## DELEGATED HOUSEHOLDER DECISION

19153/APP/2019/311 - First floor rear extension

The current proposal is identical to the previously approved proposal under 19153/APP/2018/2558. Since the last application, there have been some changes in the planning context as the Hillingdon Local Plan: Part Two- Development Management Policies (2020), the London Plan (2021), and the National Planning Policy Framework (2024) have been adopted. Therefore, an updated assessment

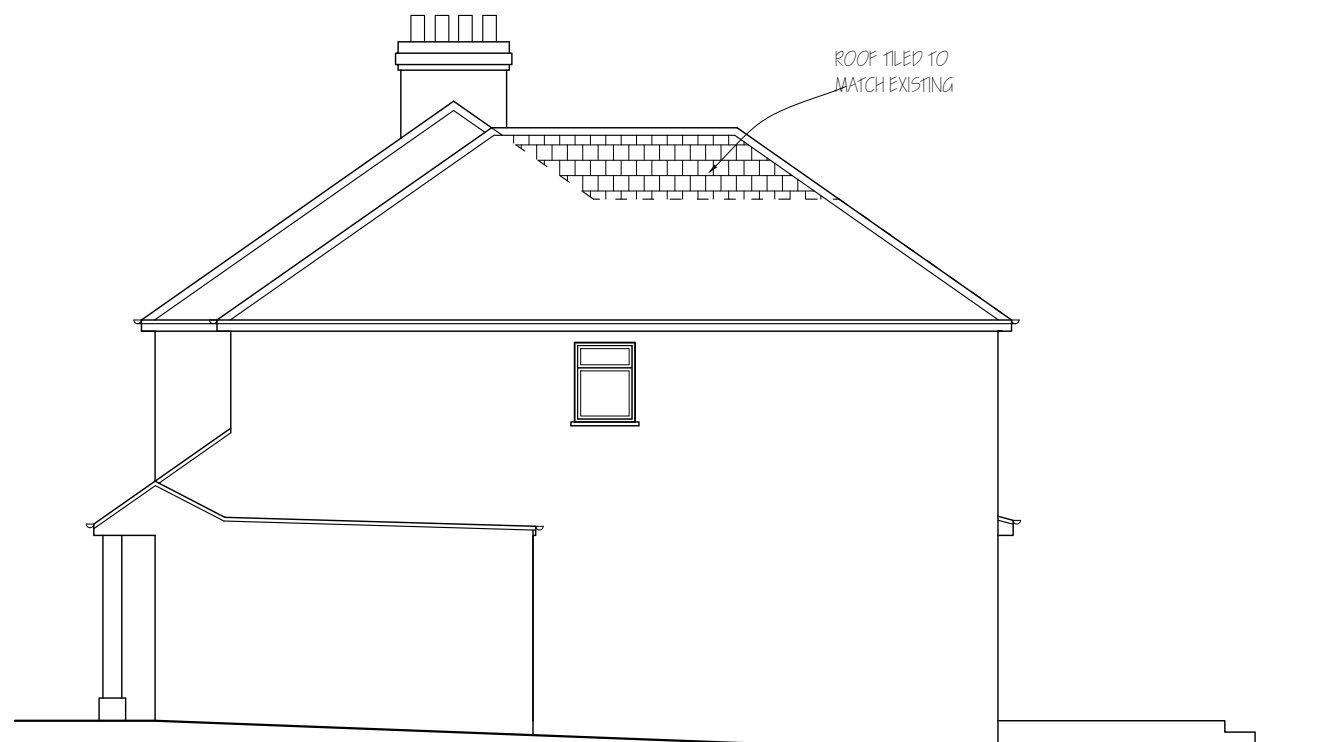
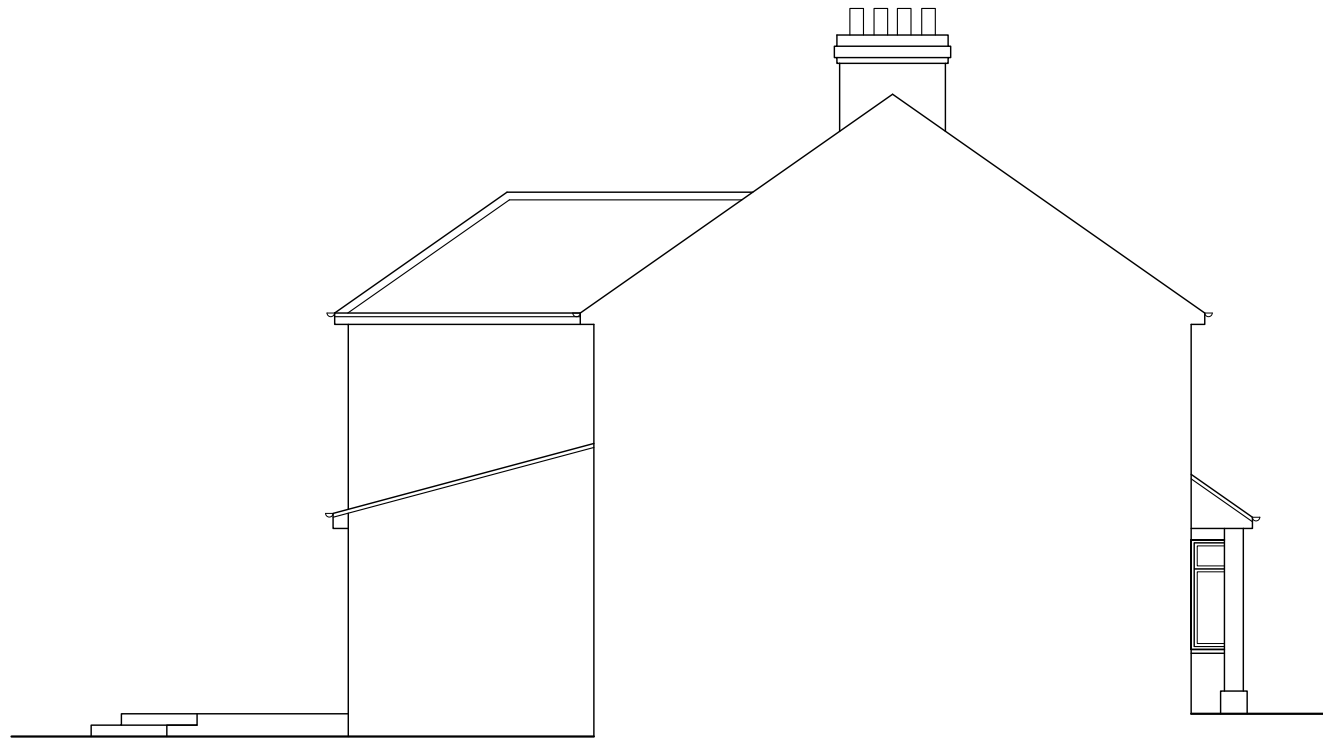
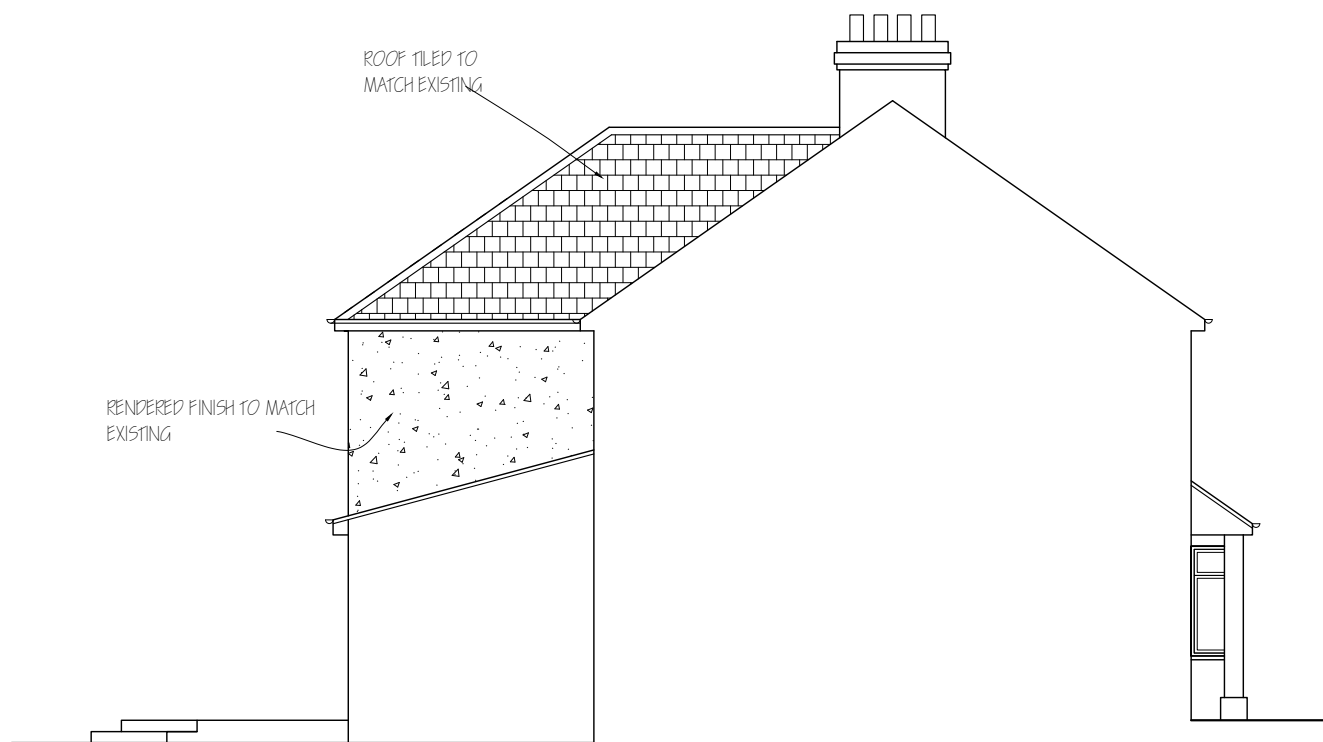
The proposed development would involve a revised rear roof design which increase the maximum height of the rear roof ridge from 5.5m to 8.1m. The height of the revised rear roof ridge would match with the lower half of the existing main ridge. Despite the substantial bulk added to the existing roof, it would feature a hipped roof design which could mitigate the visual impact of the extension and match with the existing roof design of the host building and neighbouring properties.

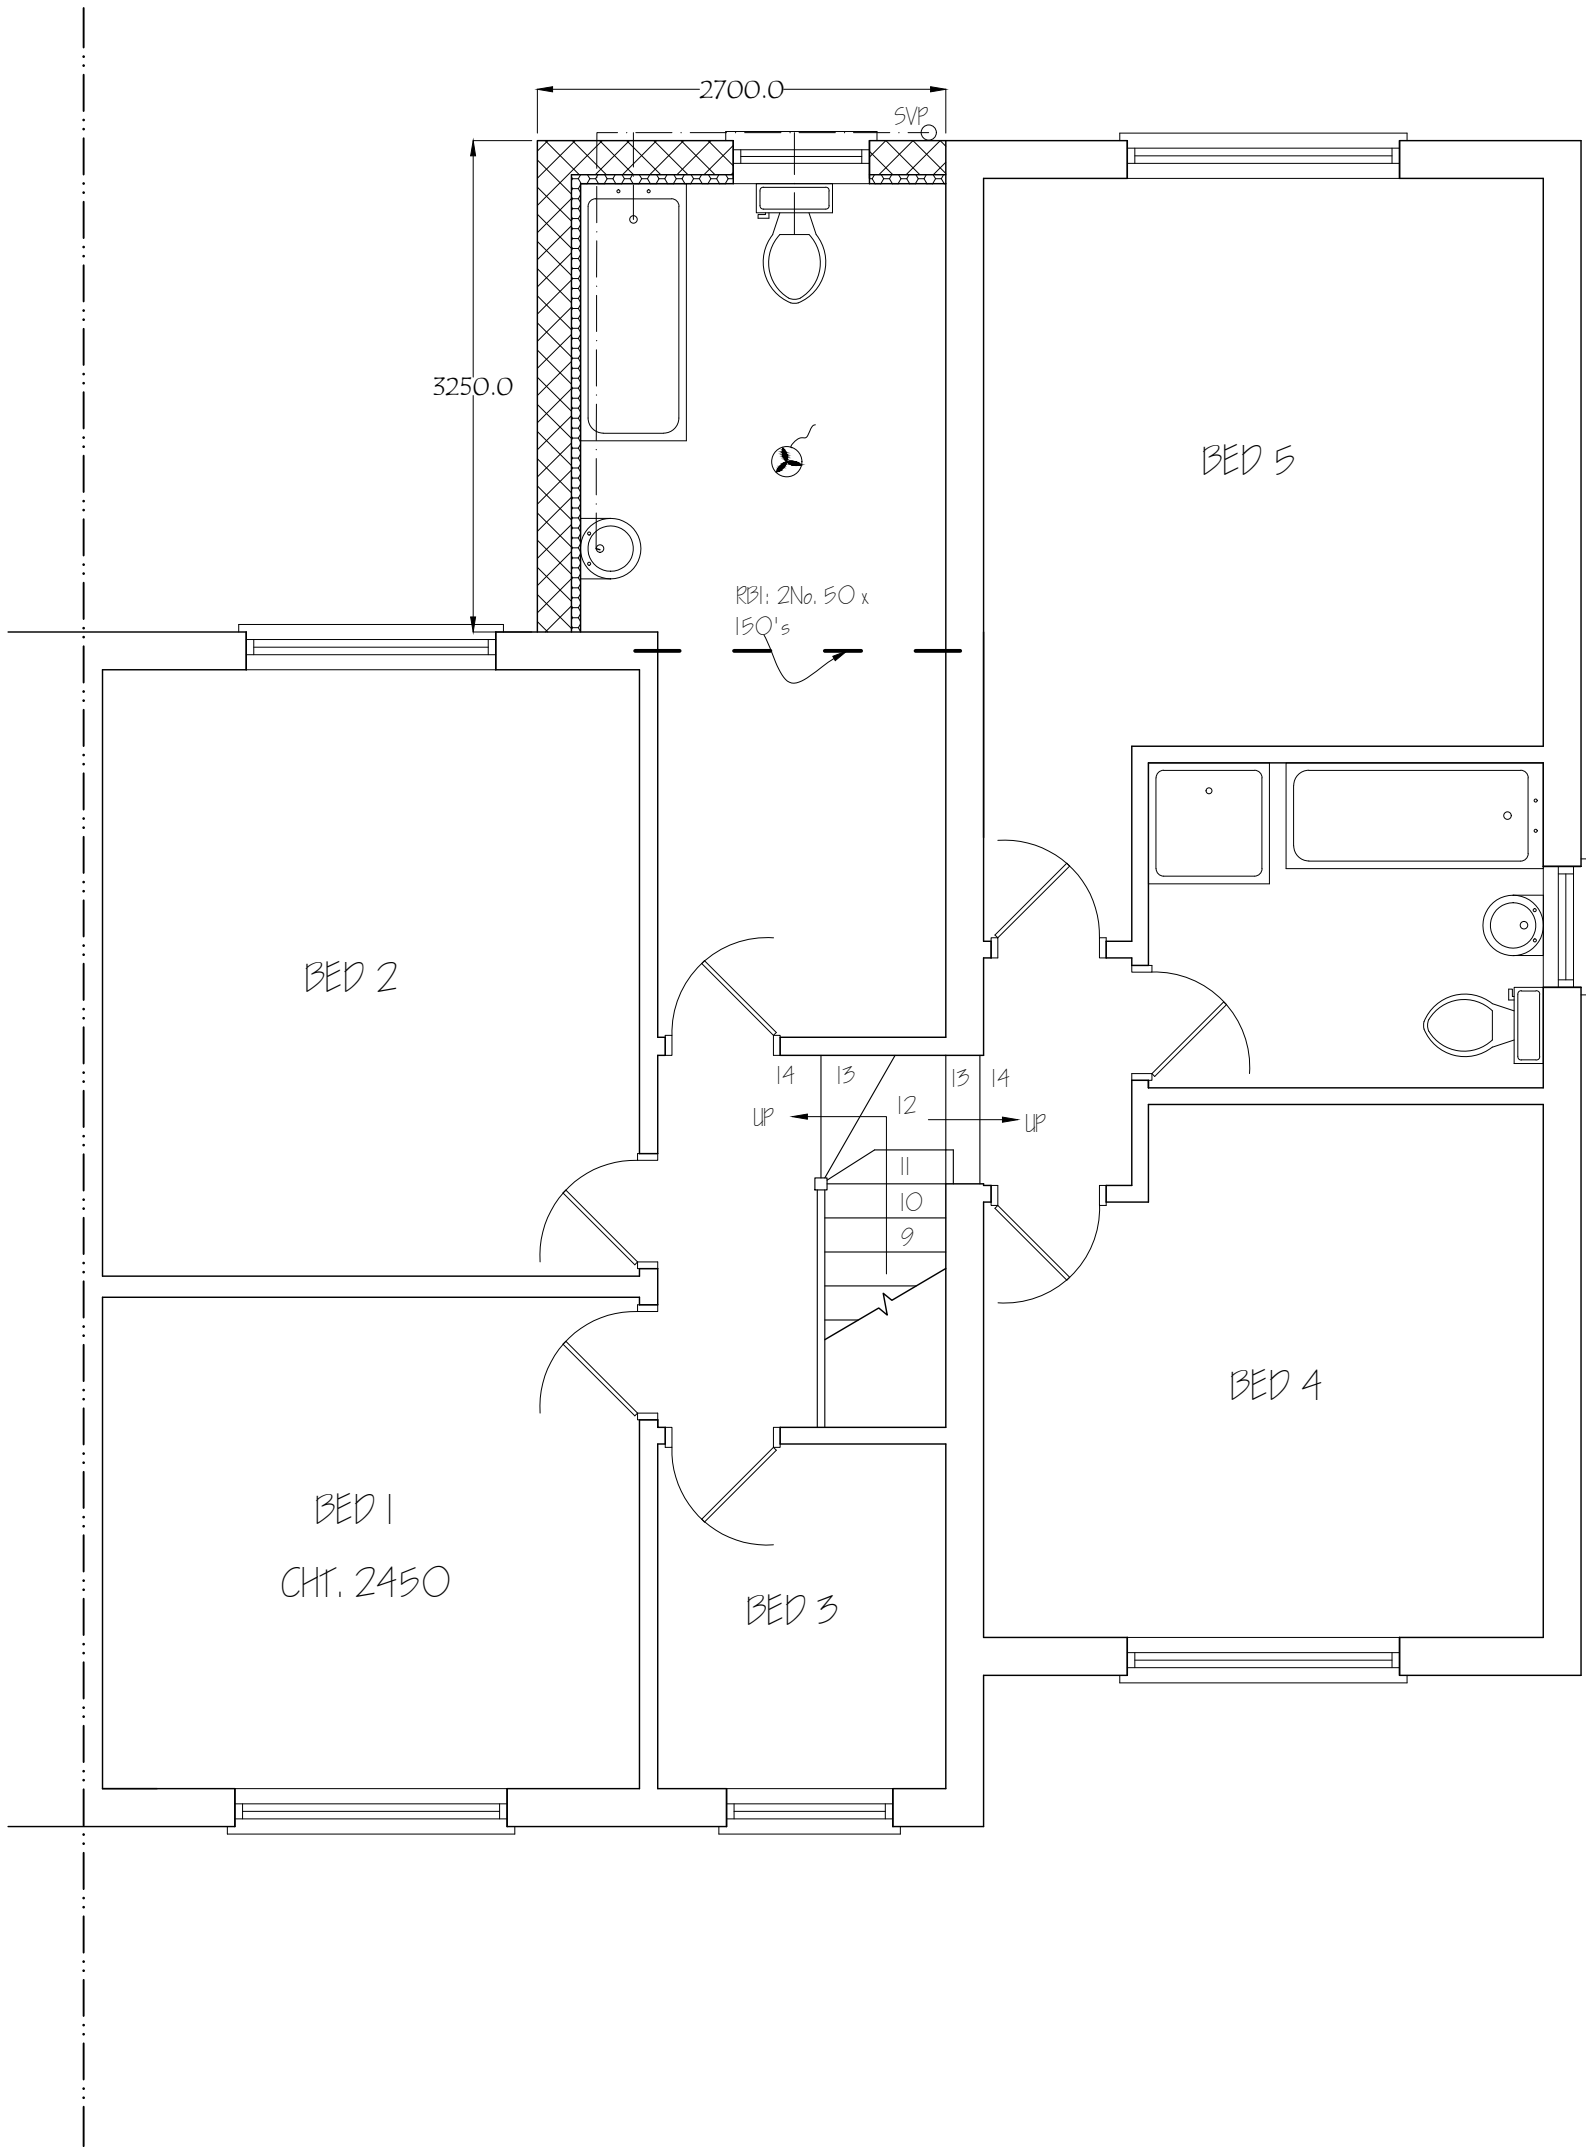
The proposed extension would be 2.7m wide and 3.35m deep itself and would have a combined width of 6.9m with the existing 2-storey side and rear extension. The proposed 1/F rear extension when combined with the existing 2-storey side/rear extension would not span full width of the existing host building as per the requirement under Policy DMHD 1.

No. 22 Gordon Crescent is the other half of the semi-detached pair located to north of the application site with existing G/F rear extension. The proposed 1/F rear extension would project 3.25m beyond the existing 1/F rear wall of No. 22 with a setback of 3m. Whilst the proposed northern flank wall of the 1/F extension would be closer to the shared side boundary than that of the existing one, it would not fall within the 45-degree line from the centre of nearest 1/F habitable window. Therefore, the proposed extension would not create significant amenity impact on No. 22 in terms of overshadowing, loss of outlook and increased sense of enclosure.

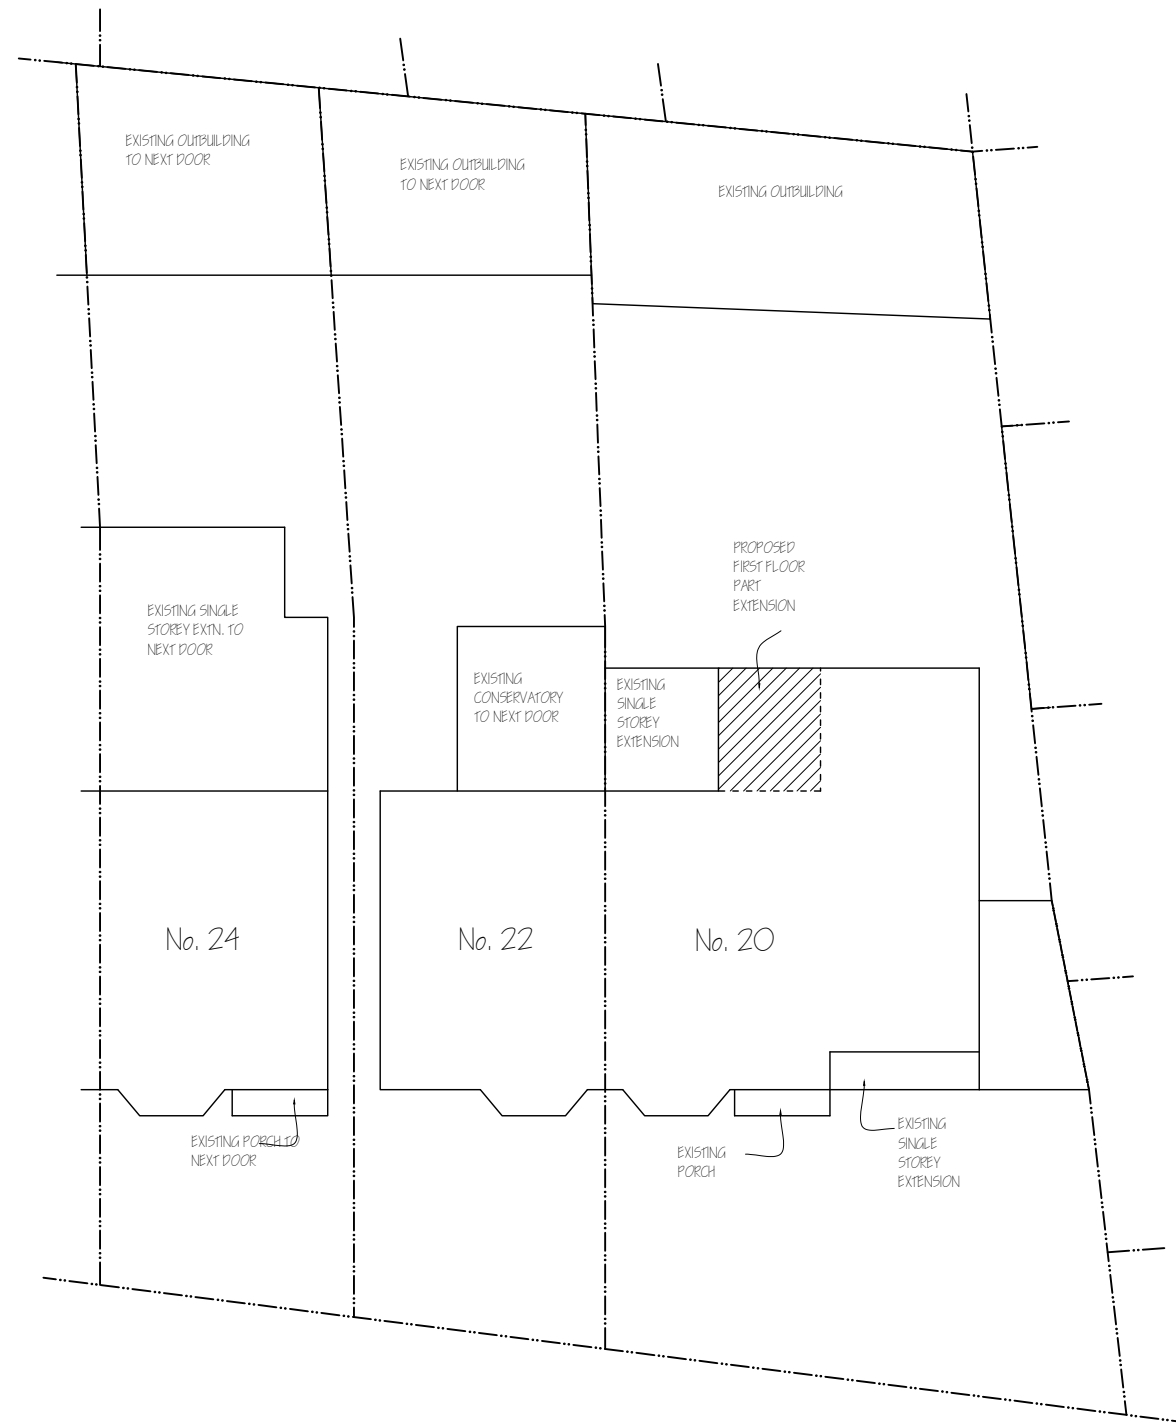
With the proposed extension in place, the rear garden would retain approximately 100sqm of private amenity space whilst the host building would be a 4+ bedroom dwelling which requires min. 100sqm of private amenity space under Policy DMHB 18, therefore acceptable.
